Grading & Erosion Control Plan_V2 redlines.pdf Markup Summary

3-22-2022

ISSUE
DATE:
SHEET:
DP-3
3 OF 10

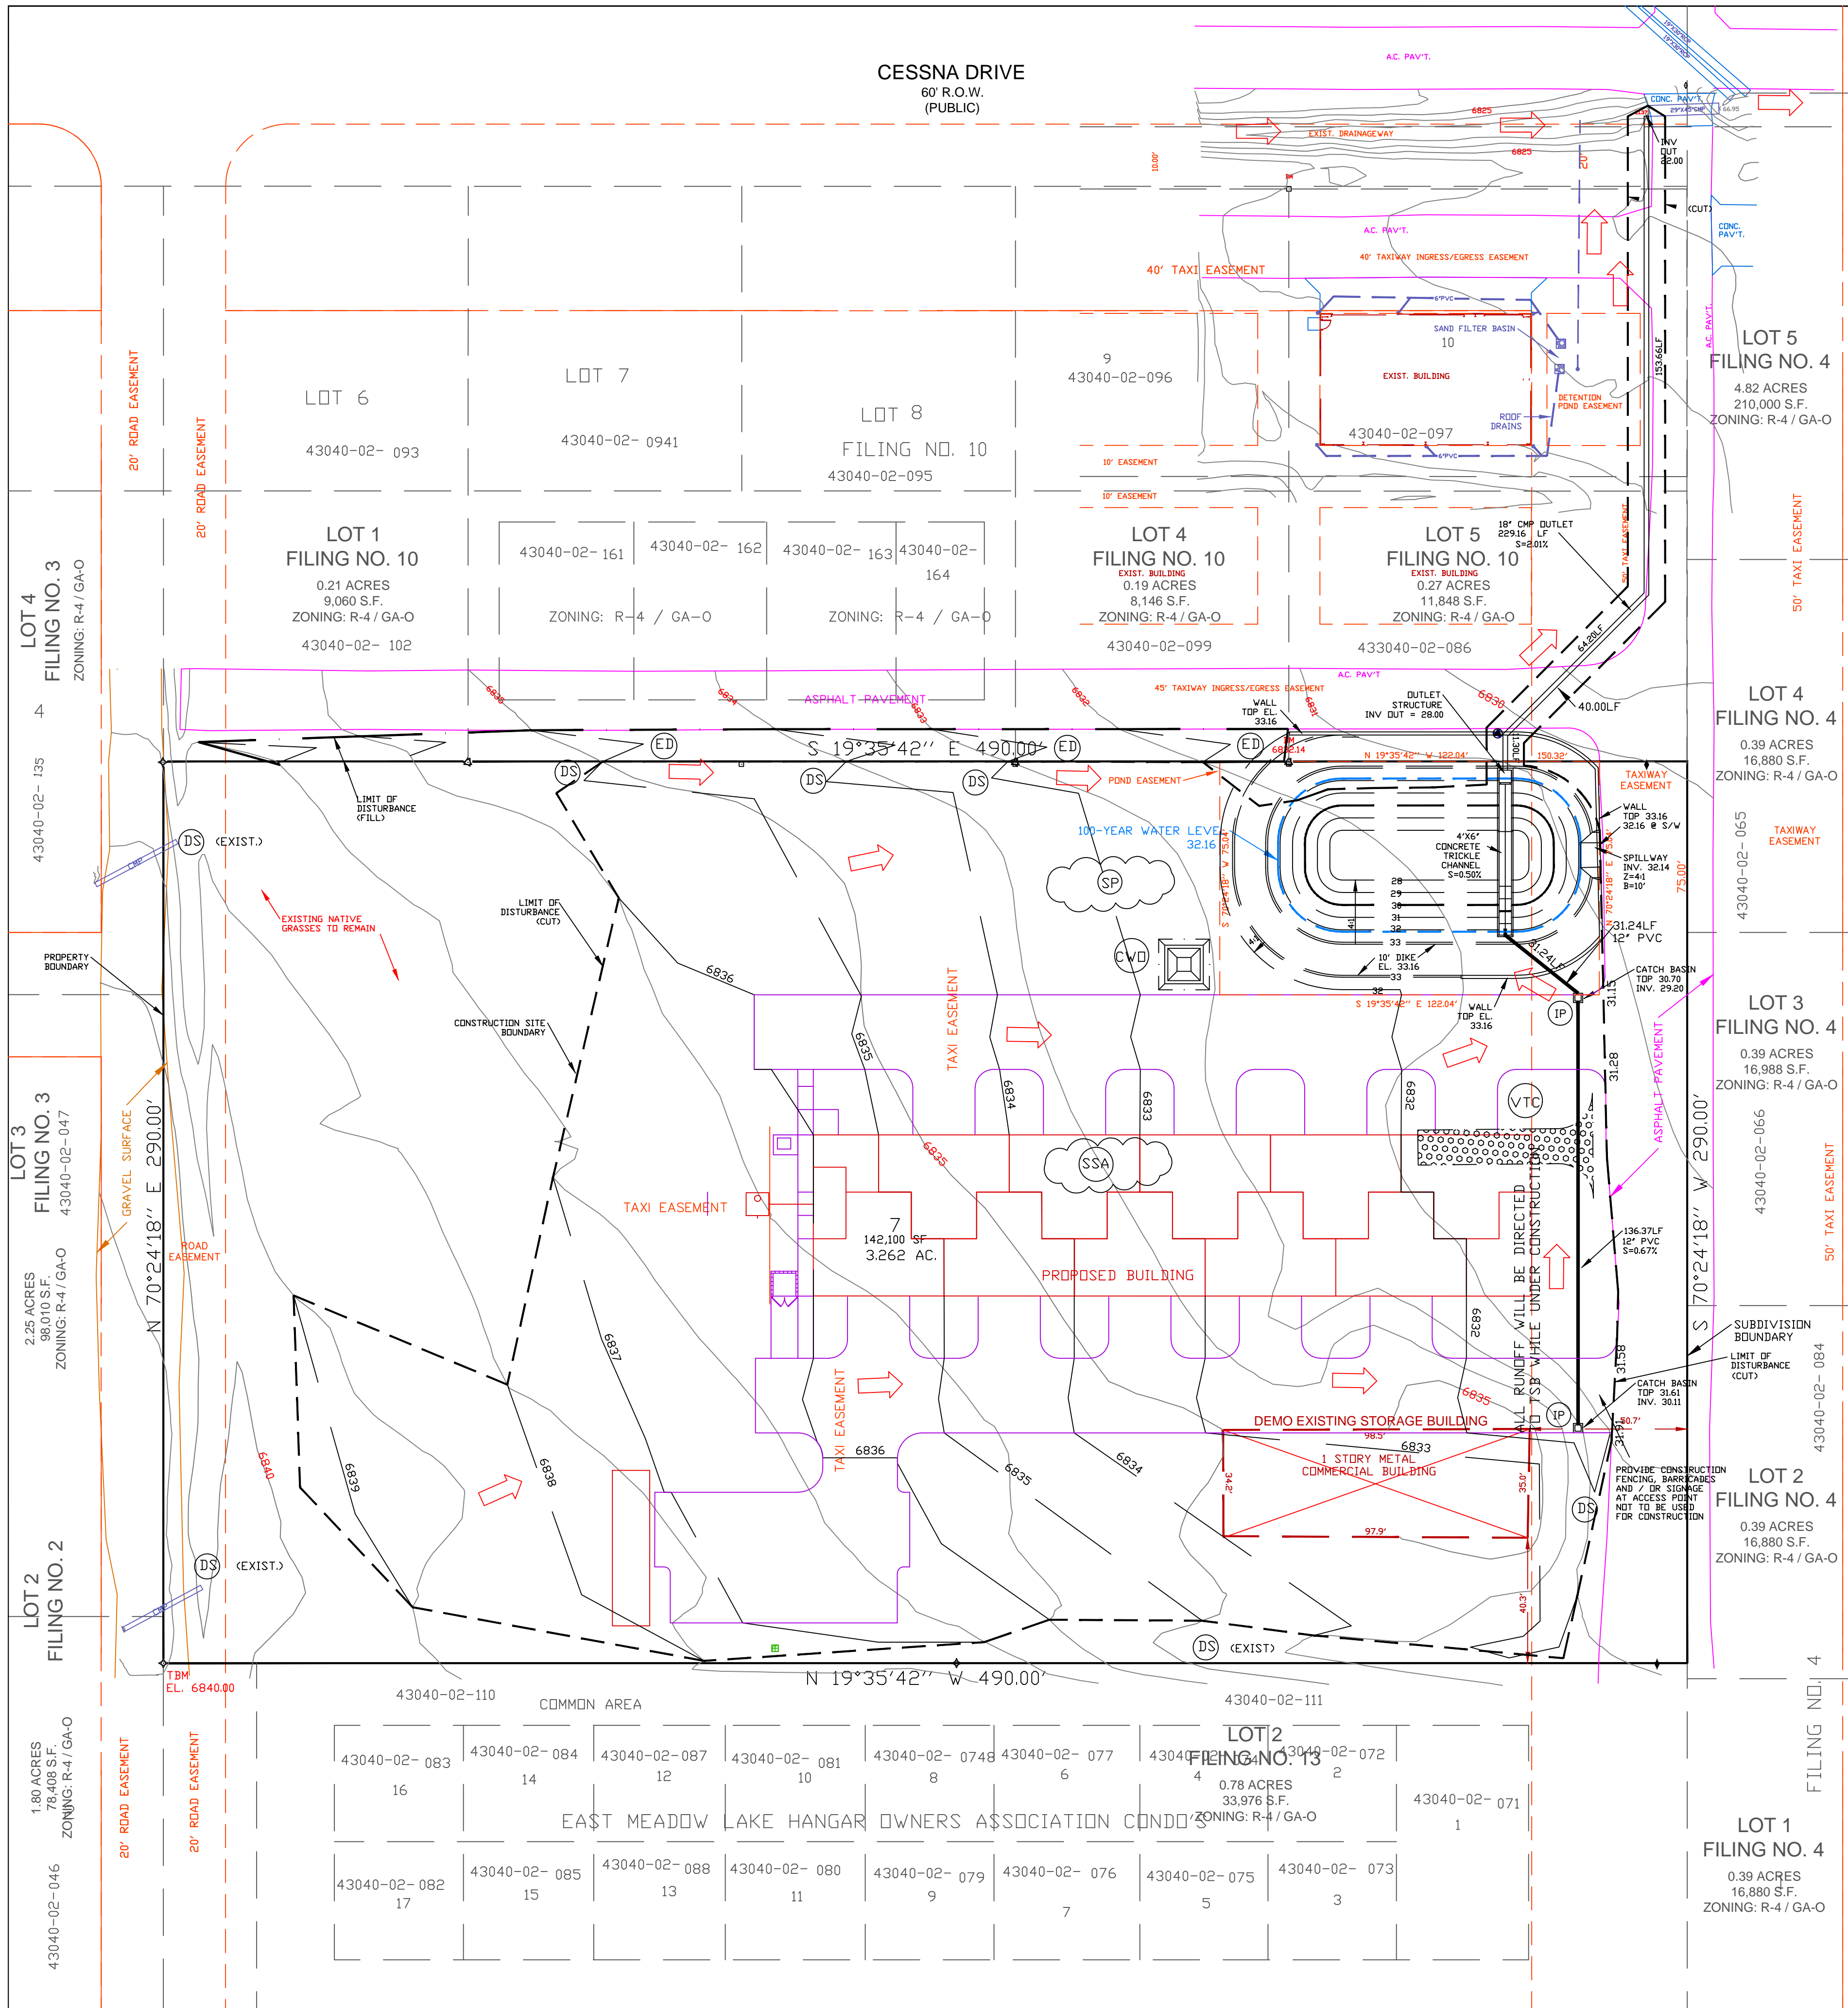
Item x. Will this pond be used as a temporary sediment basin prior to installation of any structures? Please provide details of the TSB, including riser pipe perforation sizing, number of rows, required volume, location of outlet and spillway, and tributary area to the sediment basin.

Item n. Provide construction fence to protect work areas offsite.

How will SW be directed to TSB prior to installation of sewer pipe? Provide temporary ditch to TSB to keep SW from running offsite. (SWMP Checklist Item 17g)

Item e and Item h. show construction site boundaries and property boundaries and include in legend

add notes about
 - existing vegetation (Item I)
 - no springs streams, wetlands, etc are within the project area (SWMP Checklist Item 17i)

Item w. Provide construction fencing, barricades, and/or signage at access point not to be used for construction.

Item V. Label all proposed temporary construction BMPs by phase of implementation (initial, interim, final).

Show temporary and permanent seeding locations (SWMP Checklist Item 17h)

Include inlet protection at catch basins and outlet structure

label existing storm sewers and sizes. Symbol does not match legend

include type of pipe, size, etc.

No temp all permanent. Ollie will add a note that states "see landscape plan per seeding"

Ollie agreed to put a note that states: "Construction BMPs required around catch basin if needed"

Ollie agreed to add a note: "Existing site is x% native grass cover"
← FLOW
← EXISTING

LINE OF DISTURBANCE
Ollie agreed to add a note: "All water shall be directed to TSB while catch basins are being constructed"
LOT 2
LING NO. 4
